No.	Comment	Response
<b>Key Recommendations</b>		
1	The Panel appreciates the refinements to the proposal since it last attended the UDRP in 2019.	Noted and appreciated
2	The Panel recommends further refining the integration of the development with the public realm, with particular regard to the interactions at the ground level along St-Joseph Boulevard and the 1st level along Duford Drive.	The ground level has been redesigned to provide more generous tree planting areas with increased soil volumes, which will assist in greening the public realm. The proposed development includes 2 commercial units, which will contribute to animating the public realm, as will the open space and commercial patio at the corner of St. Joseph Boulevard and Duford Drive.

PAPER SIZE: ISO Full (Breed 8) (707.00 x 1000.00mm) PLOT DATE: 7/31/2024 2:01:12 PM

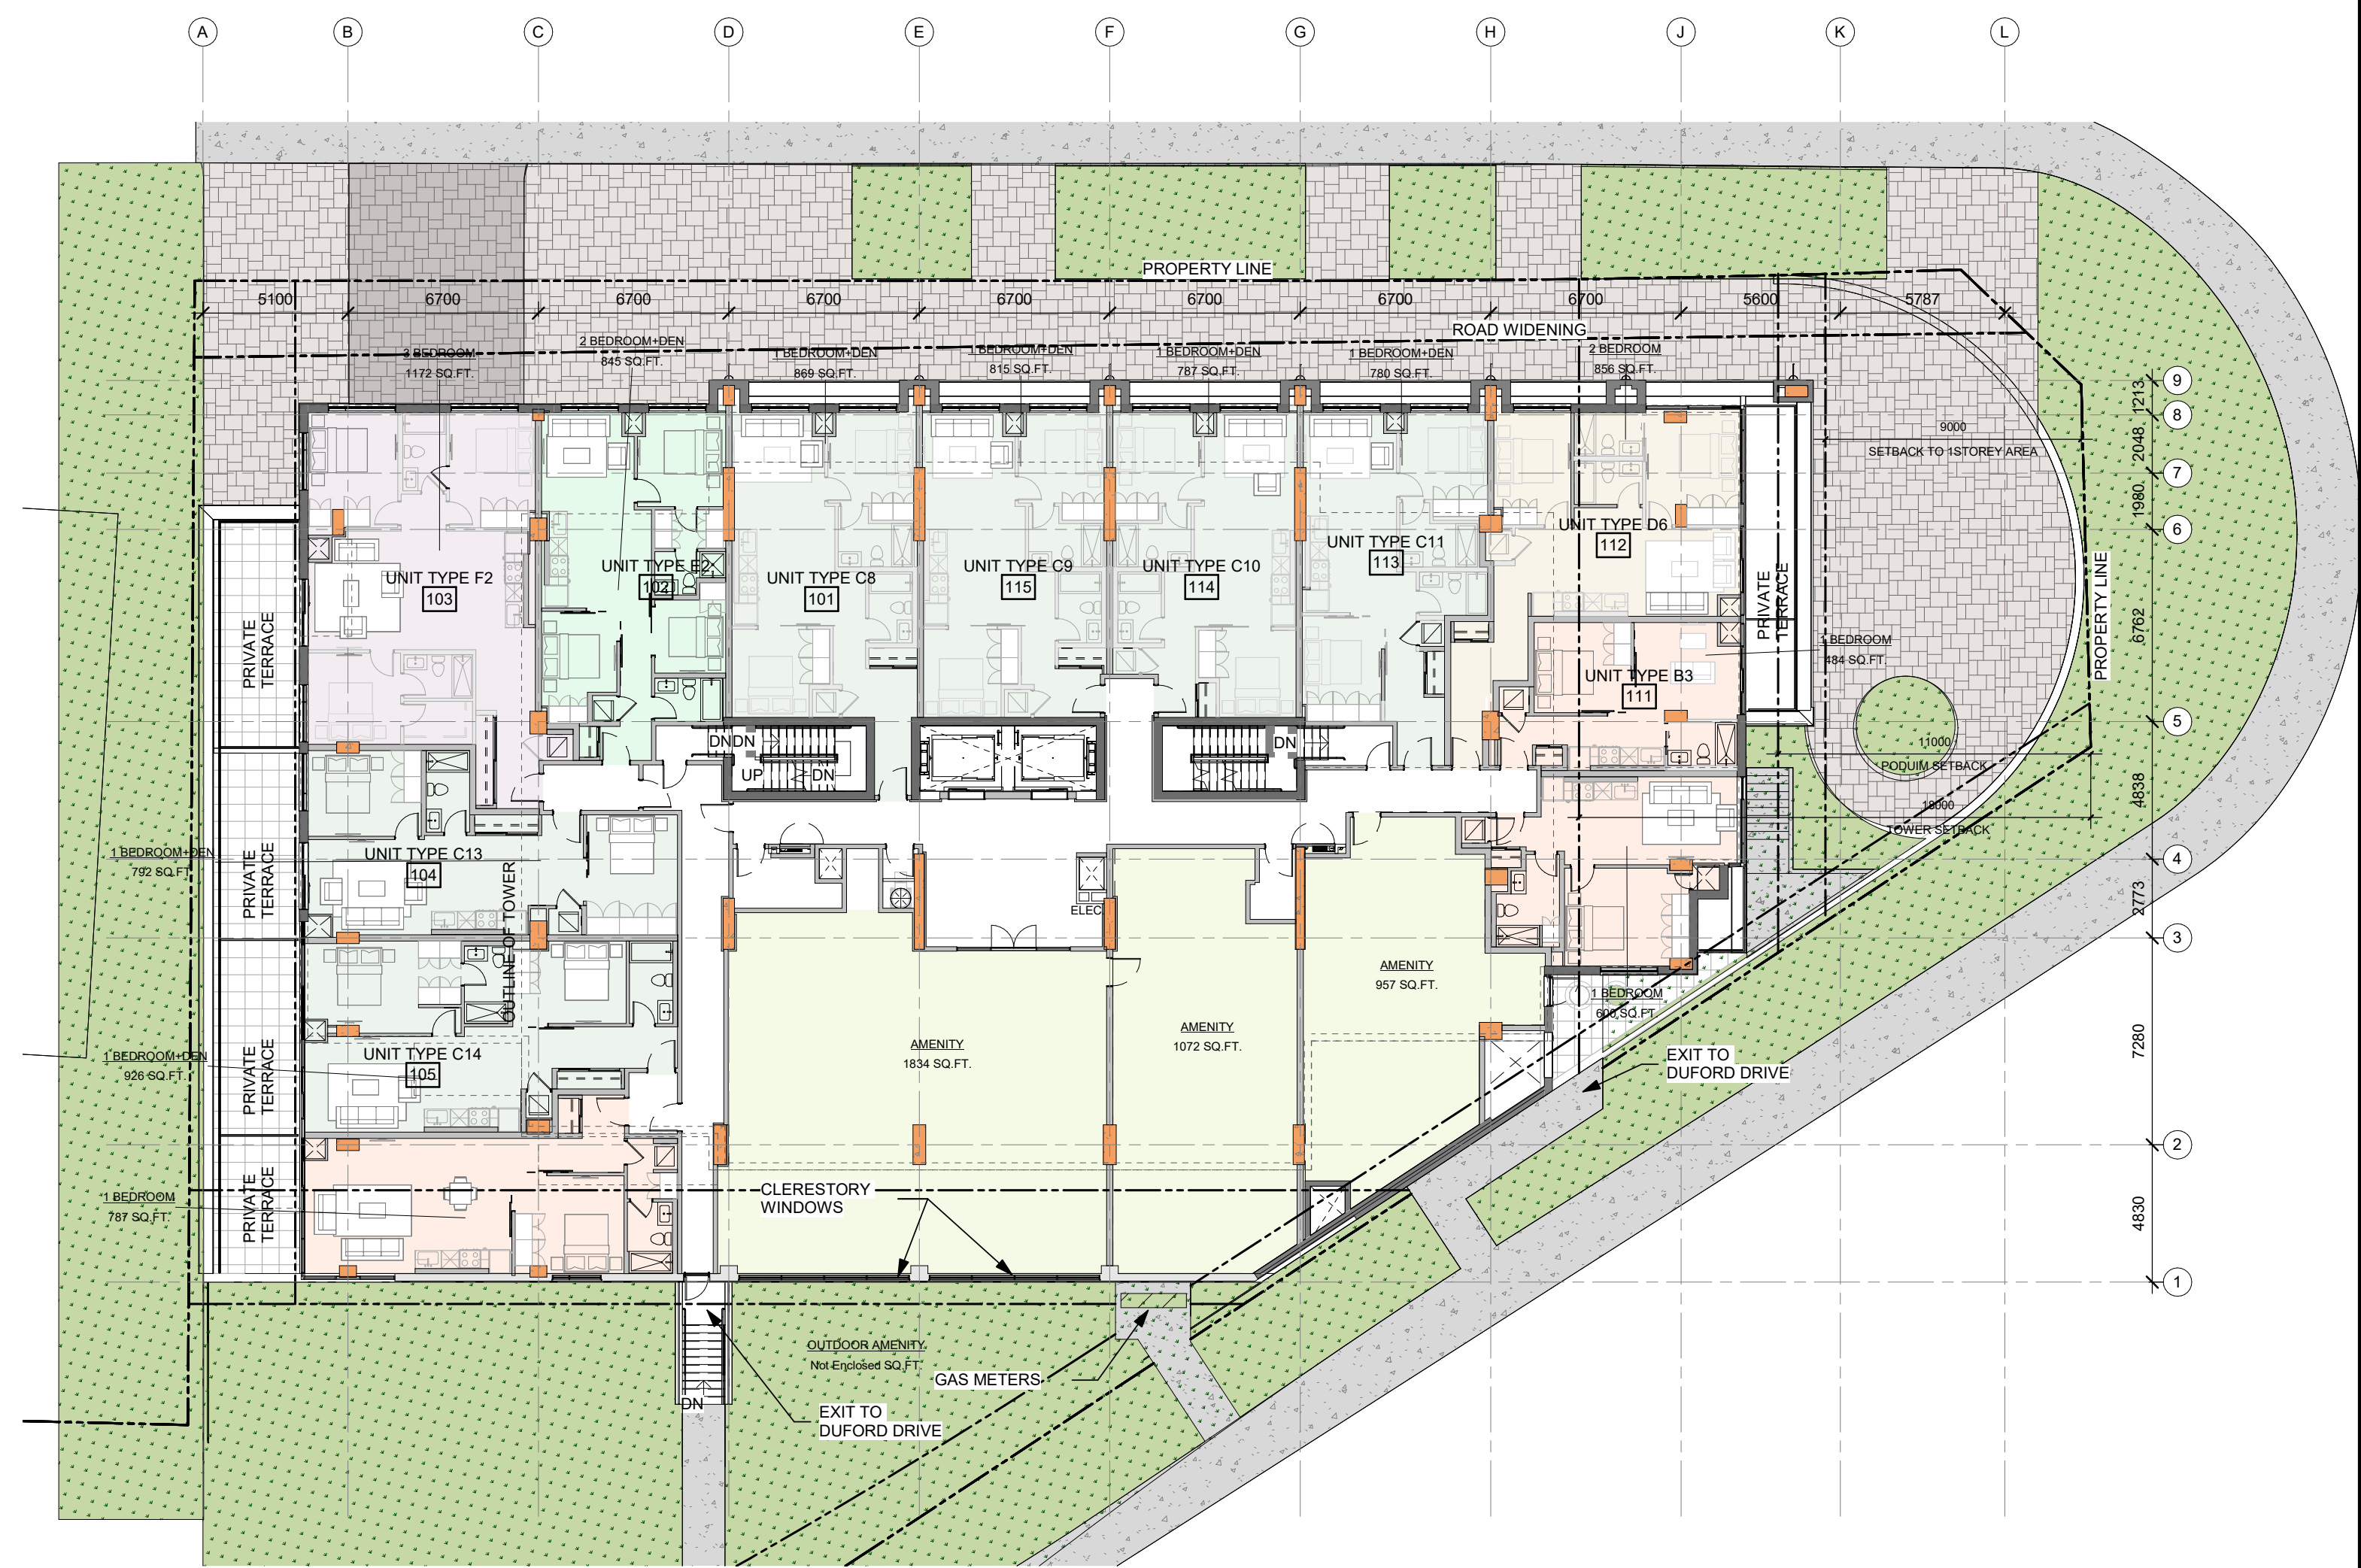
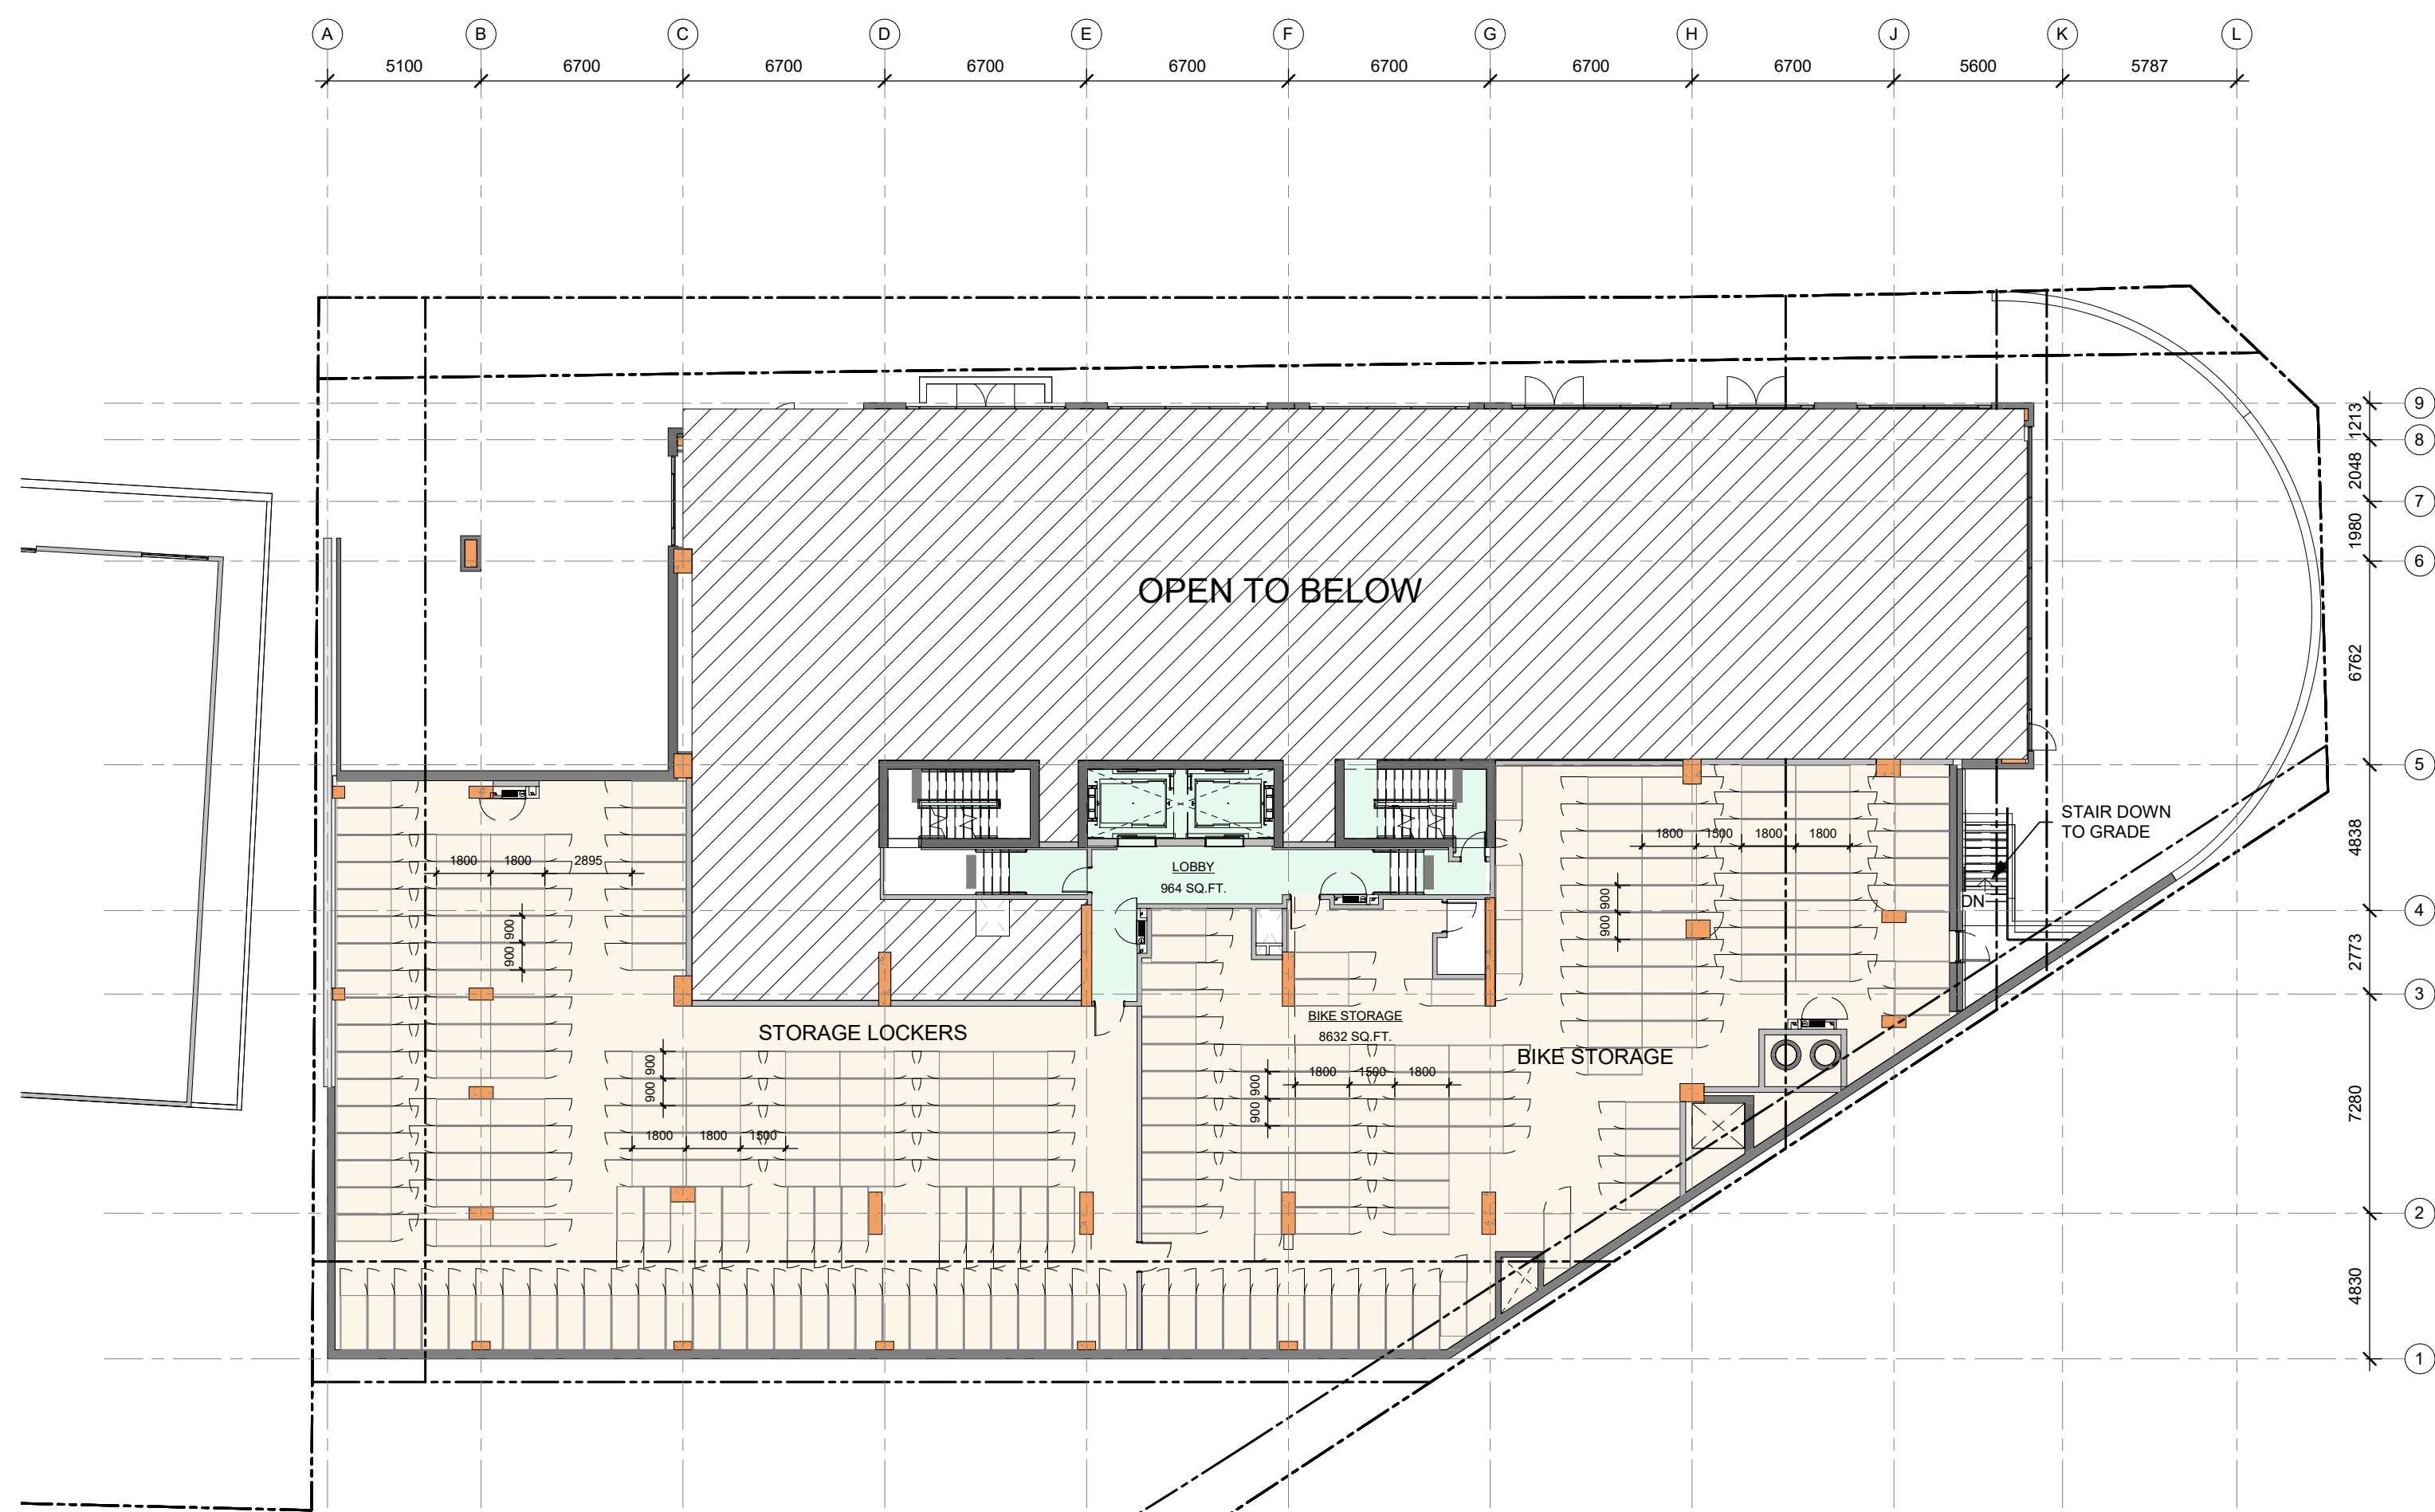
<b>Built Form &amp; Architecture</b>		
16	The Panel recommends refining the eastern elevation of the podium, as it is a particularly important view.	Noted, elevation articulation has been simplified per the updated elevations.

16.2	Consider the importance of that eastern corner view along the streetscape and as a gateway to the neighbourhood up the hill.	Noted.
17	The Panel has concerns with the window-wall element and how it wraps around the corners, both at the north-east corner and the south-west corner of the podium.	Noted, addressed in the updated elevations.

17.1	Consider using the podium brick material in place of the spandrels at both corner locations.	Noted.
17.2	Consider bringing the canopy and stone colonnade from the north façade around the eastern portion of the podium at the corner.	Noted, see response to comment to #3.3 above.
18	The Panel recommends pursuing a more contextual material for the podium than the black brick.	Noted, alternative colours were reviewed however not approved by Client.

18.1	Consider red brick, or a warmer tone than black brick, at this site.	See response to the comment above.
19	The Panel has concerns with the stark blank walls surrounding the garage entrance area.	Garage entrance area is now recessed and as such the blank wall massing has been significantly reduced.
